CHERWELL DISTRICT COUNCIL PLANNING COMMITTEE

6 October 2022

WRITTEN UPDATES

Agenda item 8 22/01683/F Unit 7 Oxford Technology Park Technology Drive Kidlington

content : BUILDING 7
PROPOSED CYCLE LOCATIONS

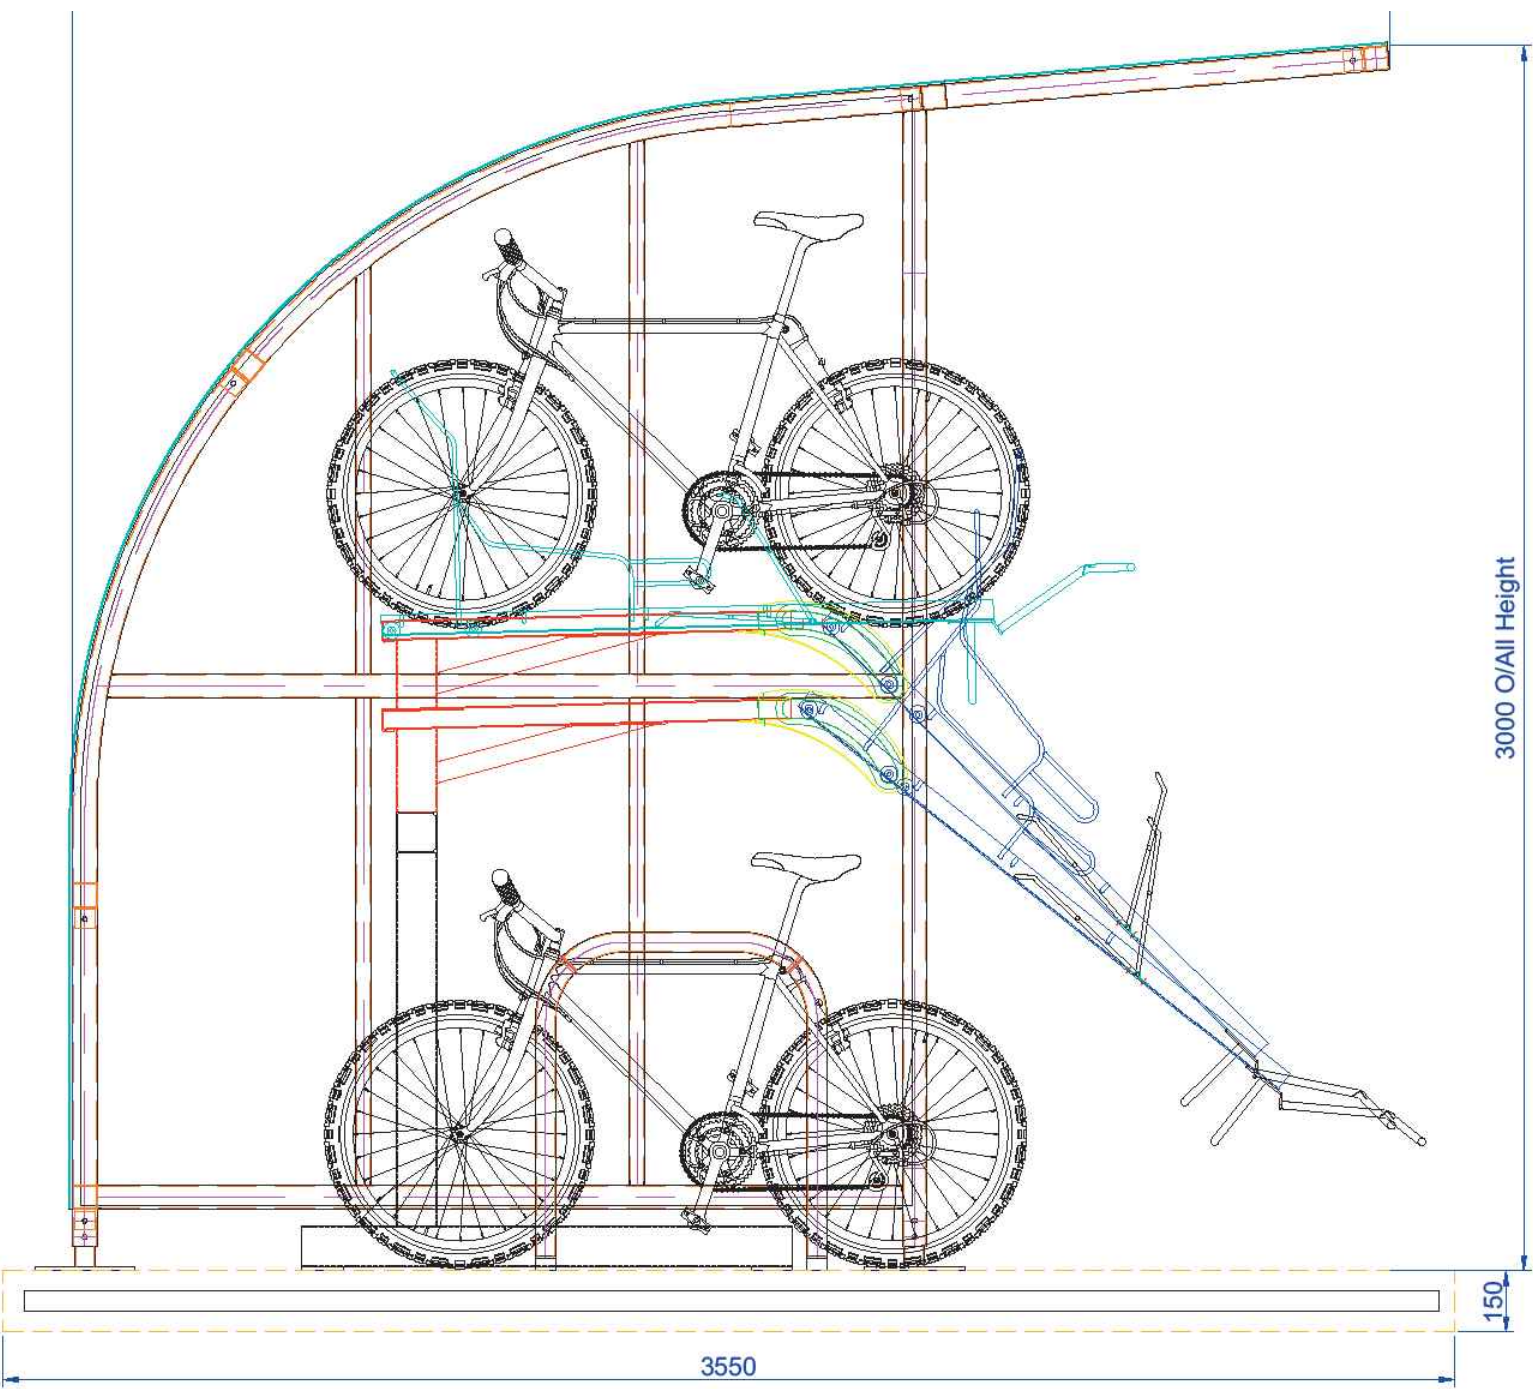
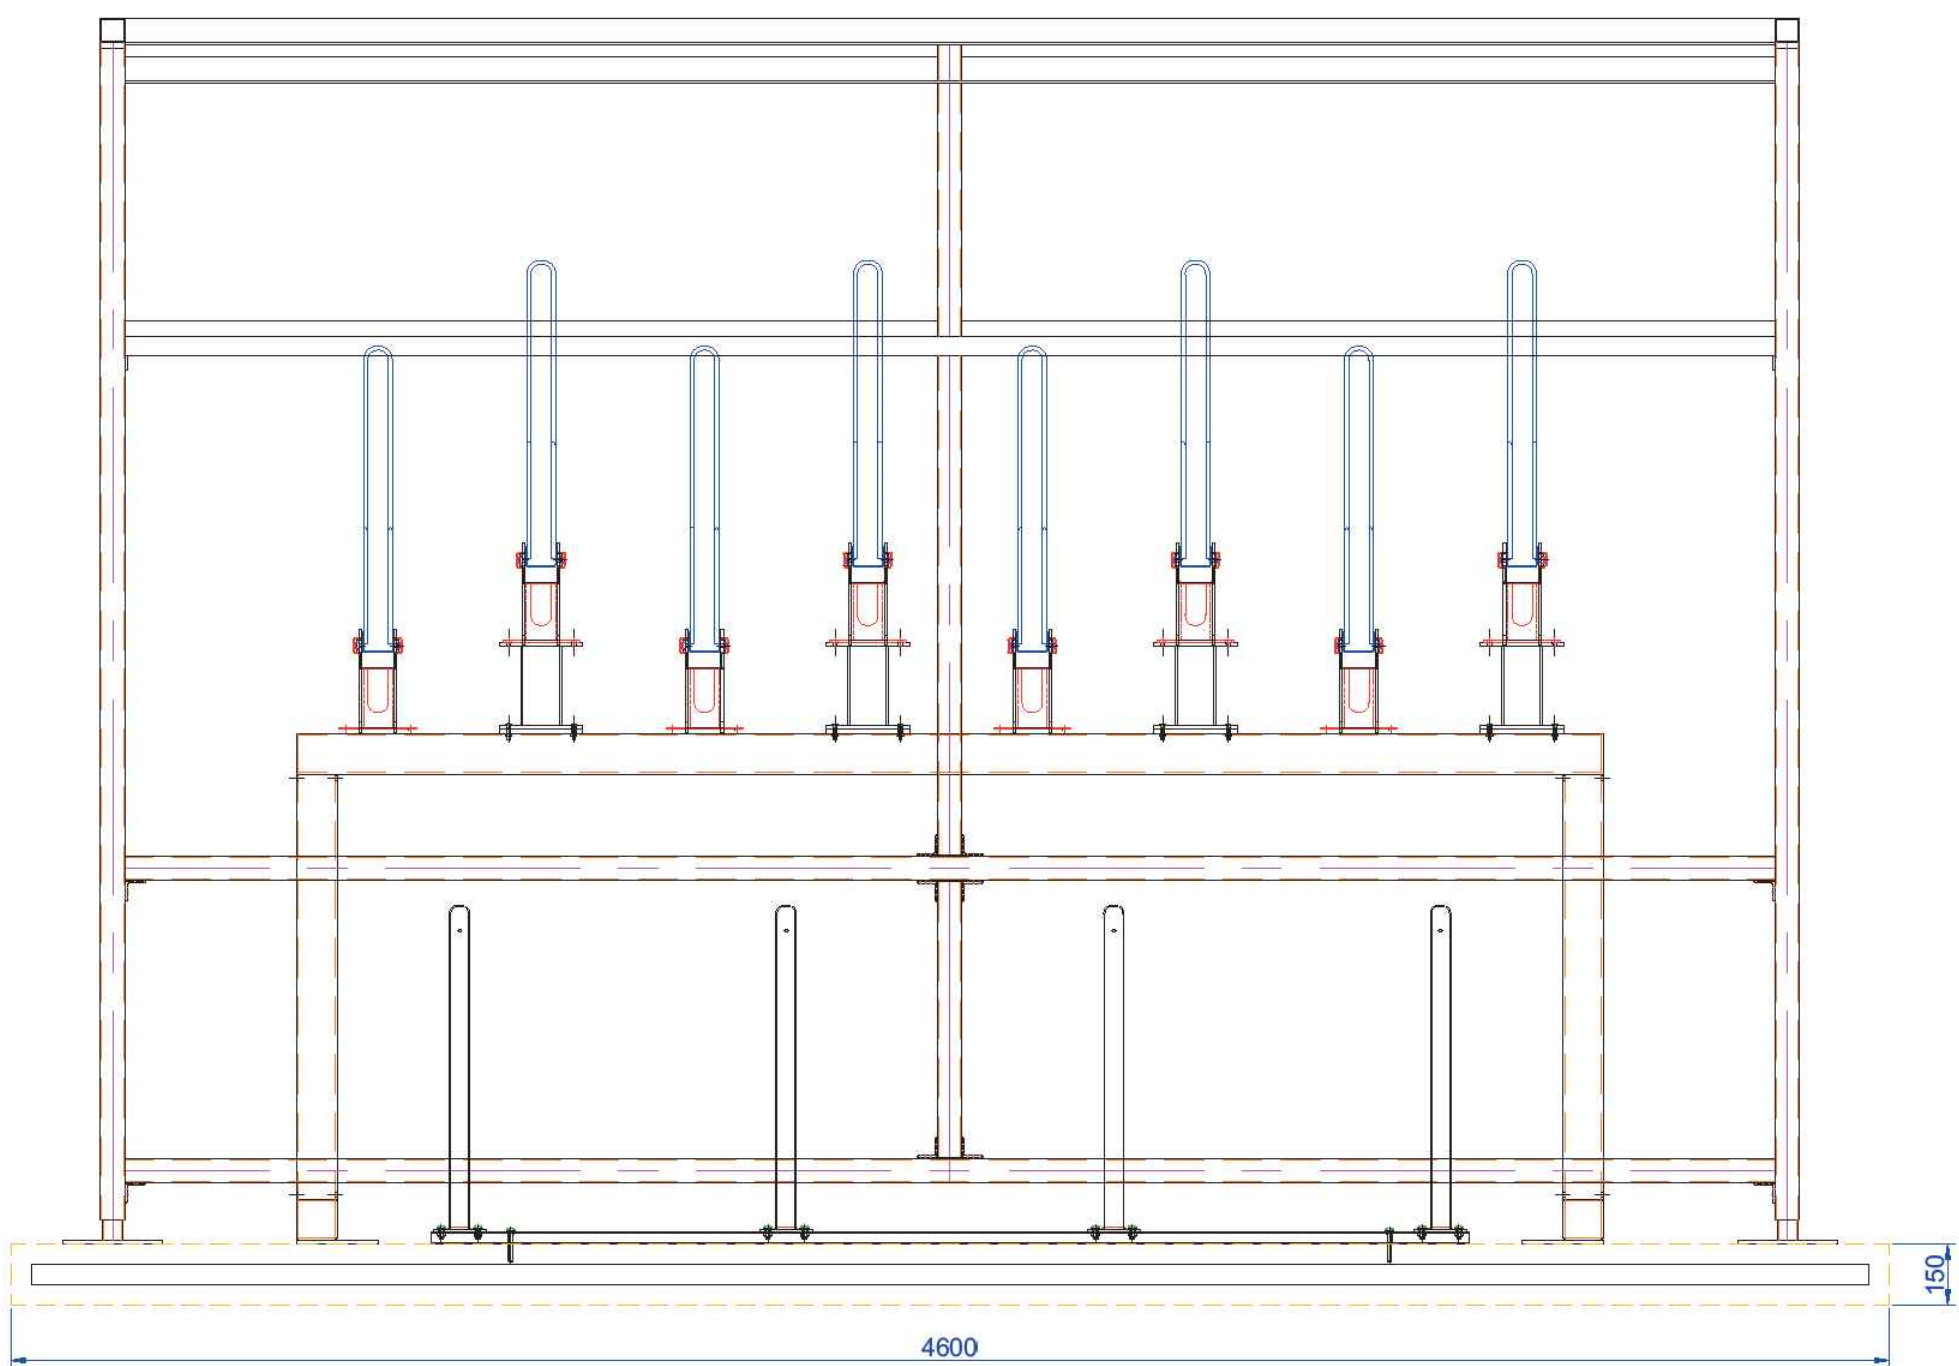
OCC Highways has clarified that there are no objections to the cycle details as proposed.
